DECISION DELEGATED TO DEVELOPMENT MANAGER

Application No:	H01-1163-20	Applicant:	Broadgate Homes
Proposal:	Details of construction management plan, precautions for mud deposits on road, boundary treatment, tree protection, recommendations for ecological retention, tree works, access road construction and surface water disposal and storage and disposal of refuse and recycling (Conditions 3, 4, 6, 7, 8, 10, 12 & 15 of H01-0203-20)		
Location:	Land Rear Of 75 Backgate Cowbit Spalding		
Terminal Date:	24th February 2021

Appendix 1. Tree protection plans – not to scale.

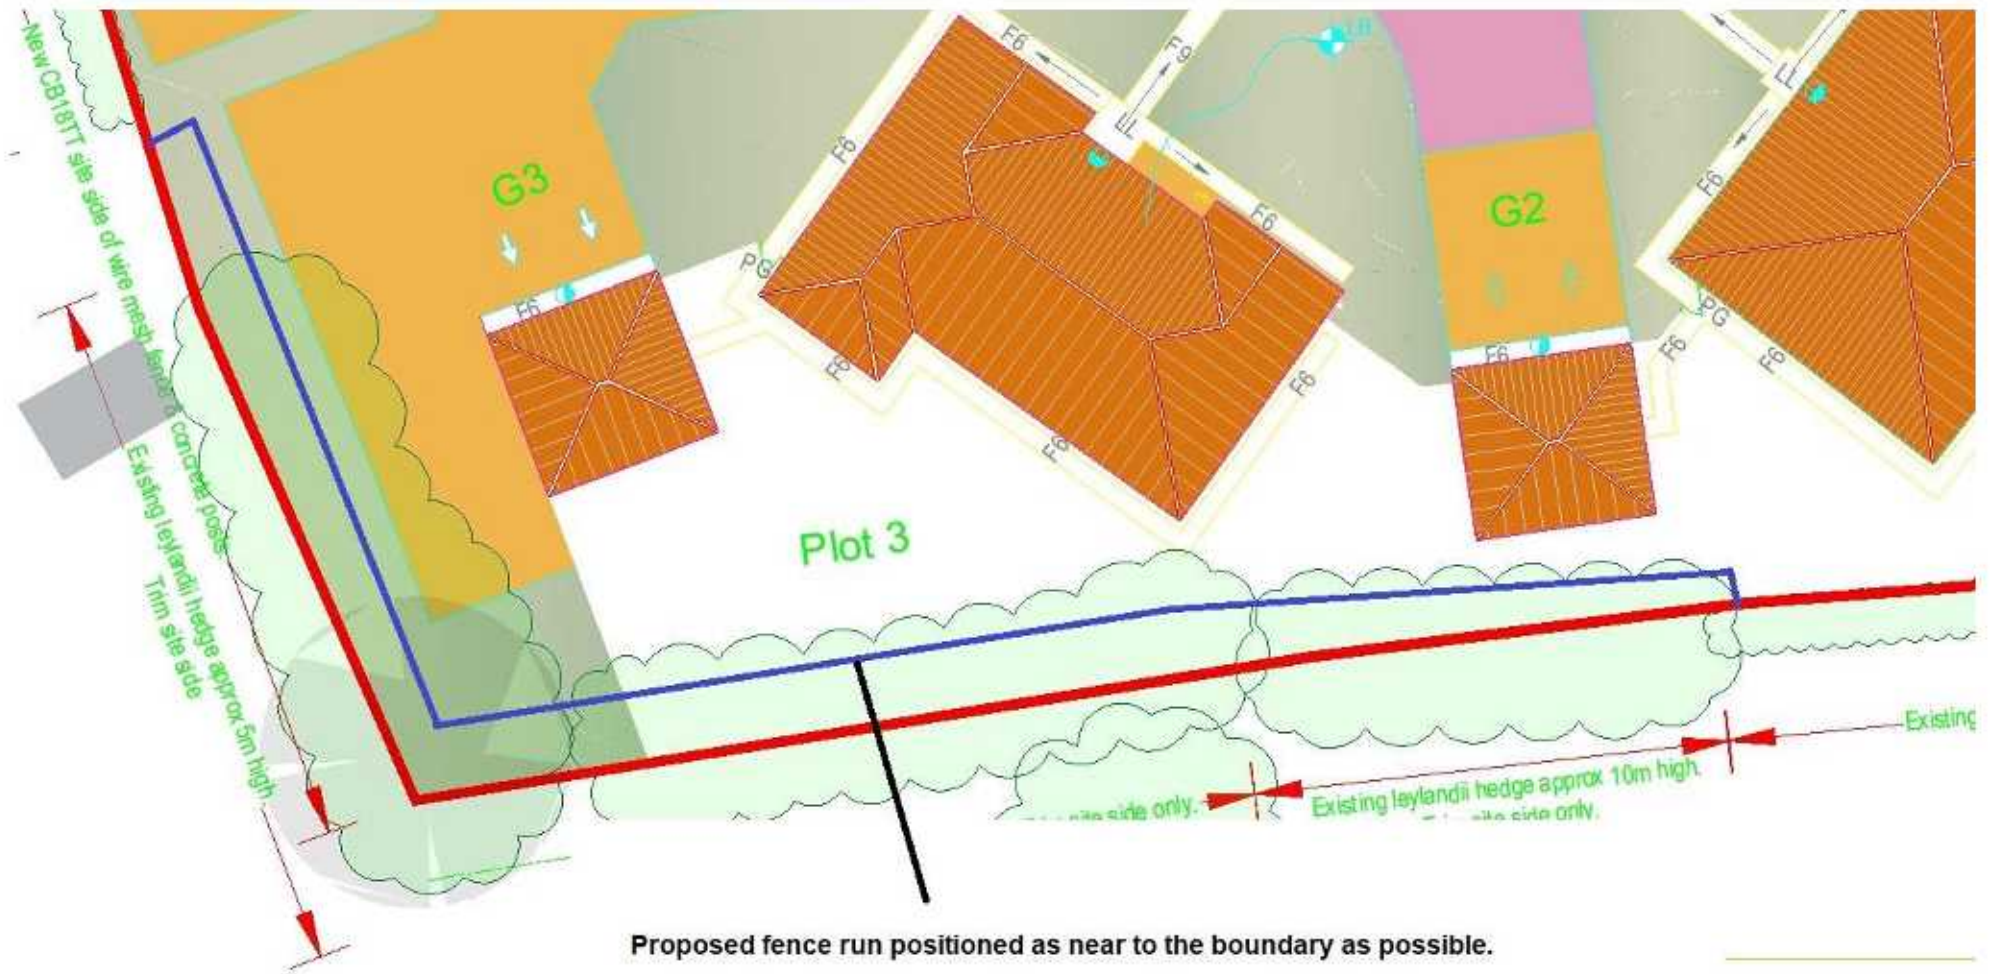
Slightly at odds with the comments on the coloured plans within the report showing tree/ hedgerow protection. Arrows to a blue line adjacent to the hedgerows to be retained state: 'Proposed fence run positioned as near to the boundary as is possible.' It can be seen that in places access for construction is at a premium, but ideally the boundary fence should not only protect the hedge line itself but also to be of sufficient distance to protect its roots. In the report text it states: 'Every effort should be taken to protect a maximum possible area of the root system'.

Would never recommend close boarded fences immediately adjacent to hedgerows. Shades sunlight from the hedgerow, which is likely to cause dieback; reduces water availability to hedgerow, as can shade rainfall from reaching the base.
